From: Graham Evans
Sent: 25 September 2013 09:58
To: Planning.Responses
Subject: FW: Planning Consultation on: FP/159/13/

NOTIFICATION FROM ARUN DISTRICT COUNCIL
Town & Country Planning Act 1990 (as amended)
Town and Country Planning (Development Management Procedure) (England) Order 2010 (as amended)
Planning Permission
APPLICATION **FP/159/13/**
NO:
Registered: 23rd September
 2013
Site Address: Land at Rookery Farm Worms Lane Flansham

Grid Reference: 496400 101200
Description of Works: Change of use from production of timber for bio mass use (Sui Generis) to land for private outdoor fitness training (D2 Assembly and Leisure) (resubmission of FP/102/13/). This application is a Departure from the Development Plan.

Site Plan

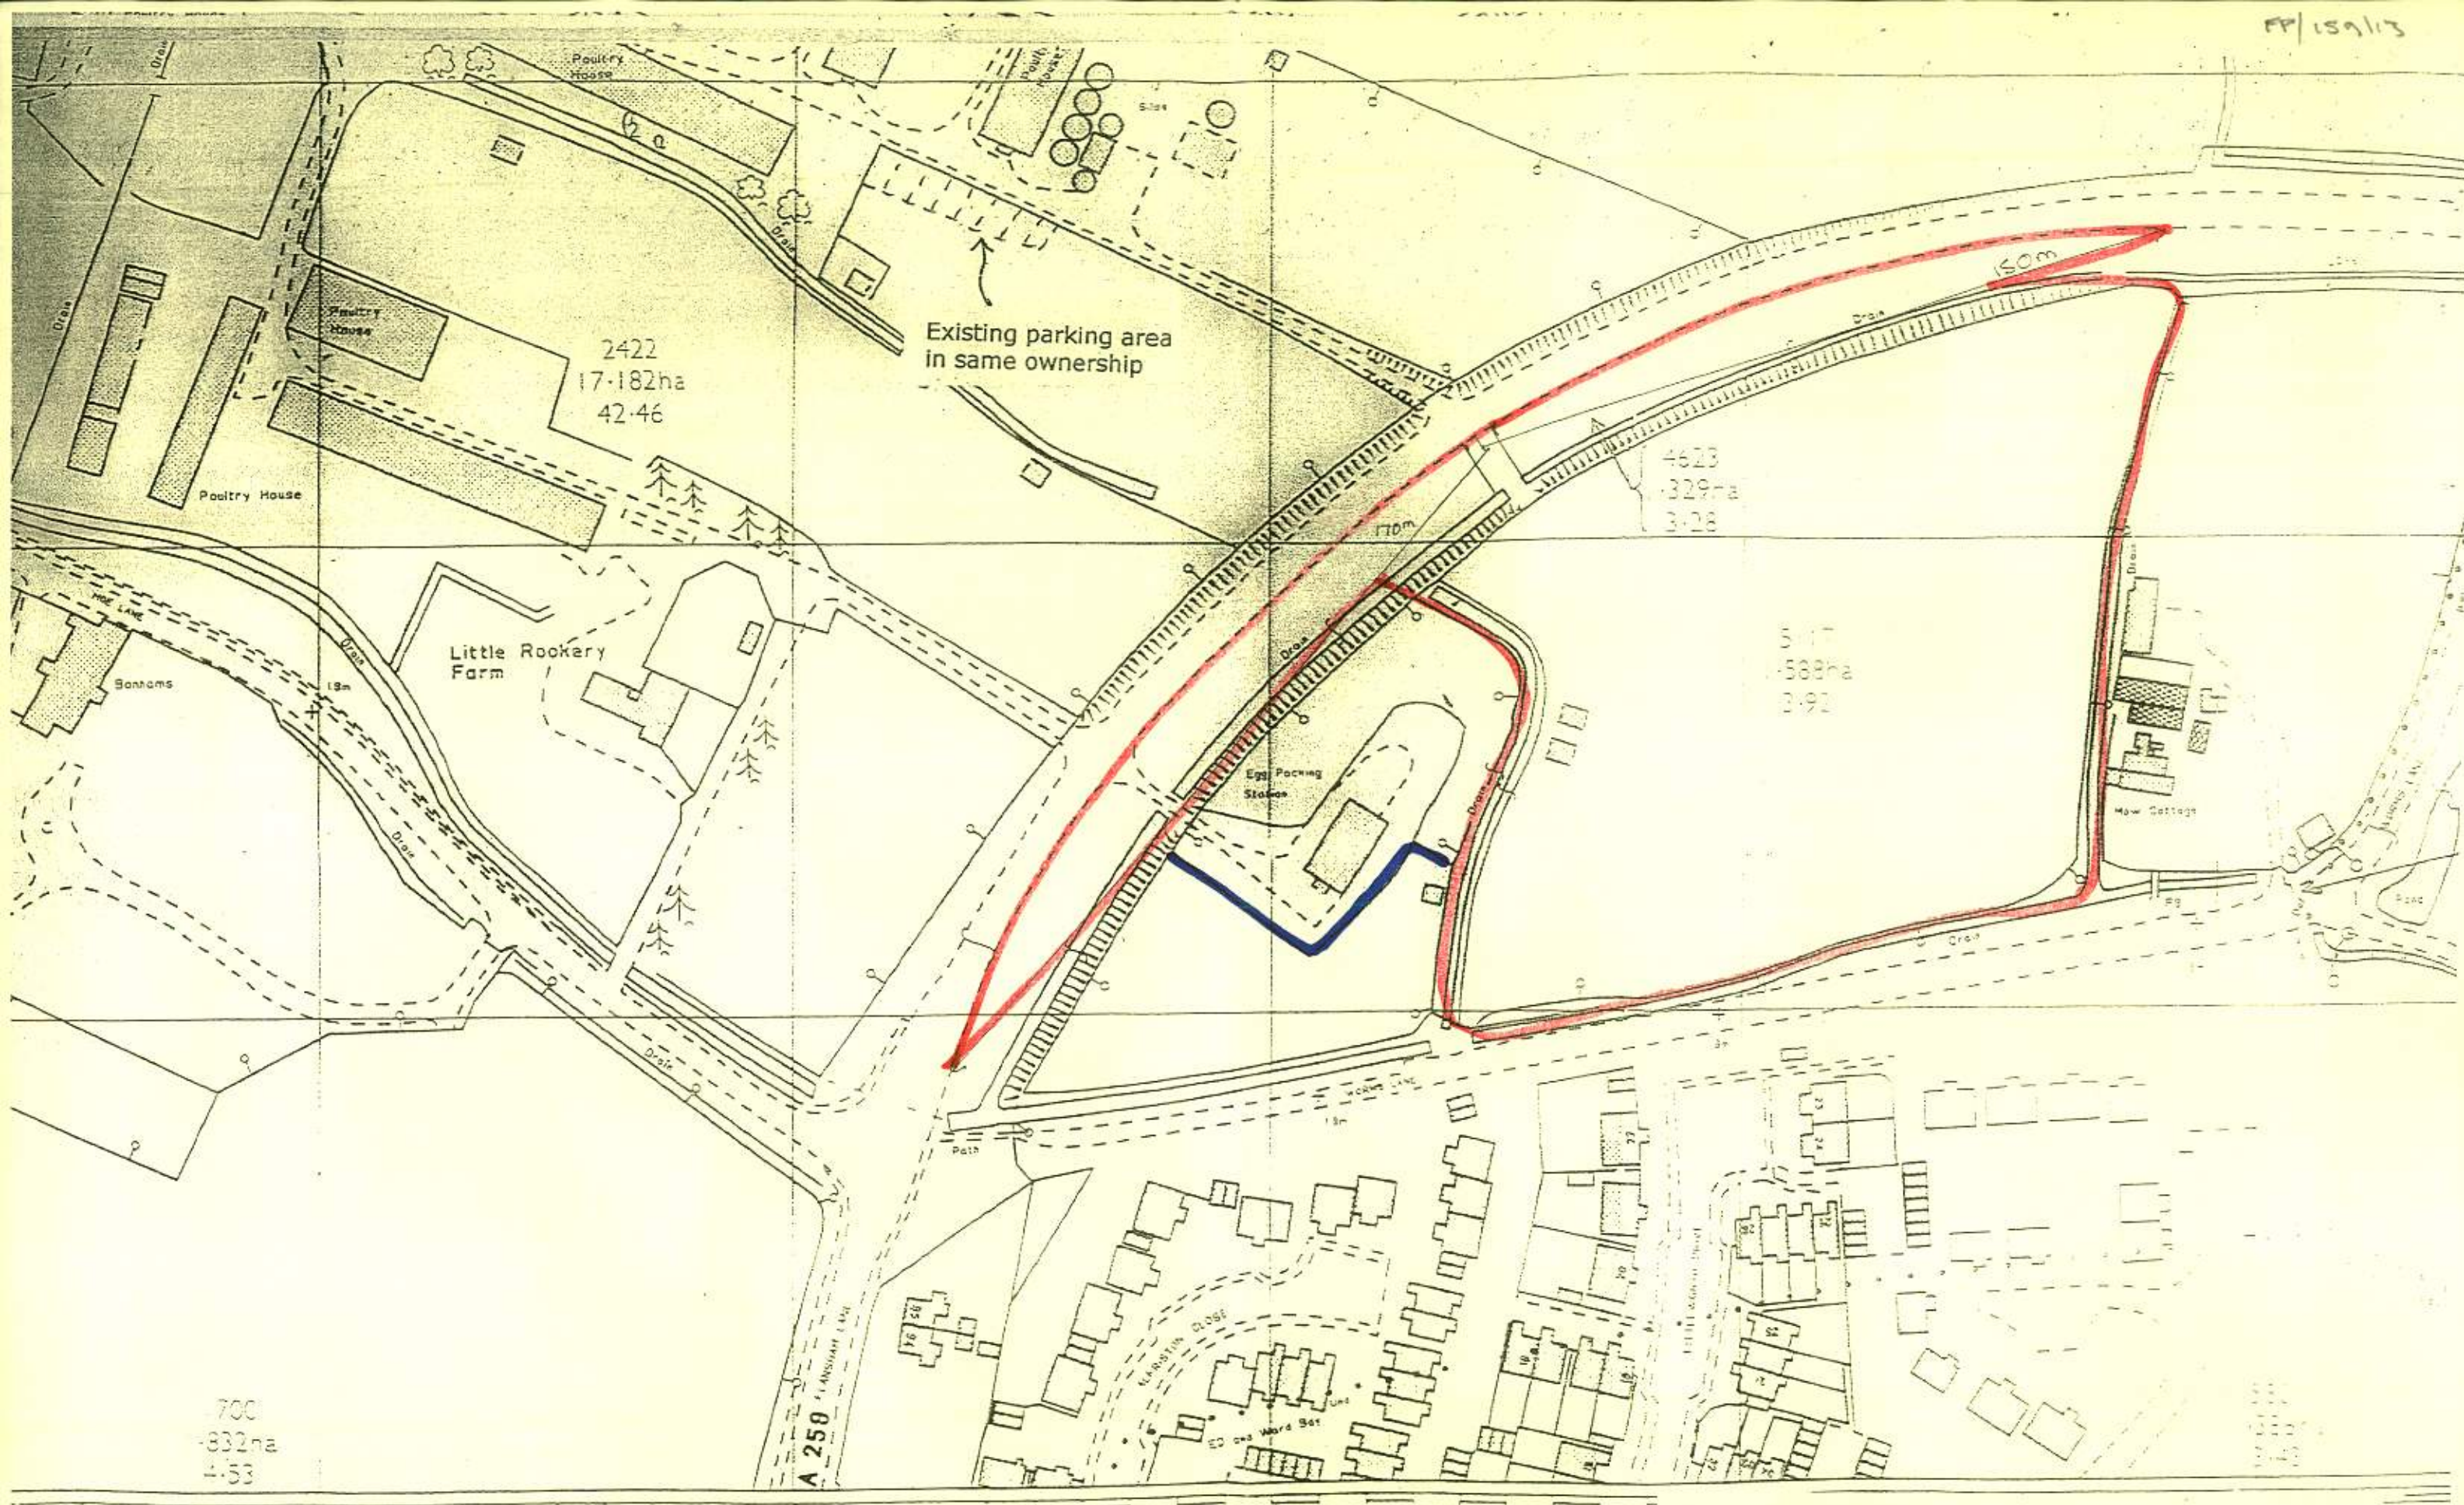
I note the local objection and concern in respect of noise from the previous proposal. It is assumed that the principle noise source will be voices of the participants/instructor rather than any significant noise produced by the apparatus used? The revised proposal relocates apparatus and participants/instructor further away from noise sensitive receptors and consequently any noise produced will be attenuated to some extent by the increased distance.

The proposal suggests that shrub planting could be undertaken along the southern boundary, whilst trees and shrubs provide very limited attenuation to the passage of noise they can be helpful, particularly under breezy conditions, in masking a noise source.

Standard condition EHN14 may be considered appropriate to ensure that noise arising from activities on site is not significantly audible at the boundary of noise sensitive premises. The scheme might usefully include proposals for managing and monitoring noise, instructor training/awareness, and dealing with complaints.
